D Street

Nell – the following is a summary of traffic signal design comments.

VALLEY STREET & "D" STREET INTERSECTION
SCALE: 1"=10'

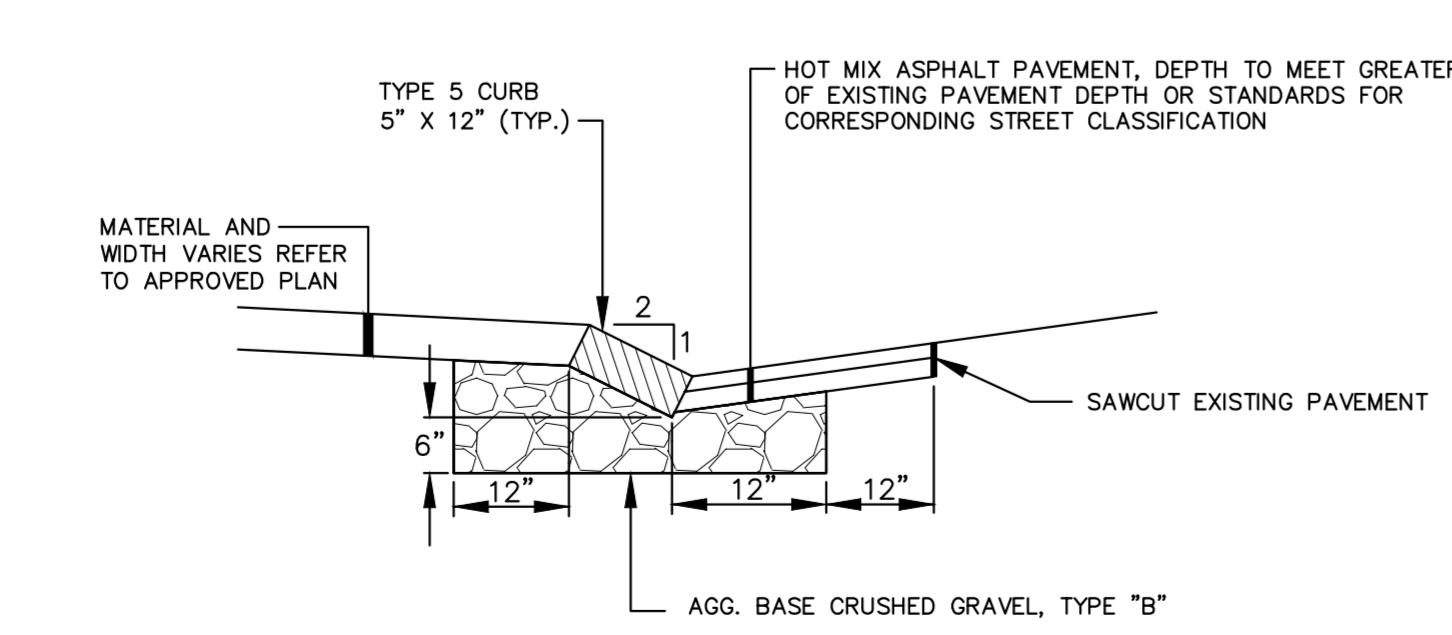
- The mast arm located on the southeast corner is labeled as a “Proposed 12’ Pedestal Pole”. This shall be corrected.
- I do not support the location of the utility pole in the flare of the sidewalk ramp located on the southeast corner.

- Although the MUTCD does not specifically note standards for cone of vision for pedestrian signal heads, it is suggested that they be located as close as practicable to a pedestrian looking directly in line with the crosswalk.

- The Applicant shall confirm that all equipment will be located within the public right-of-way. A summary of construction impacts to private property should be noted.

- The mast arm on the northwest corner should be depicted.
- A pedestrian signal head for crossing St. John Street should be depicted on the northeast corner mast arm.

- The Applicant should document that the push buttons meet MUTCD requirements for accessibility and separation.
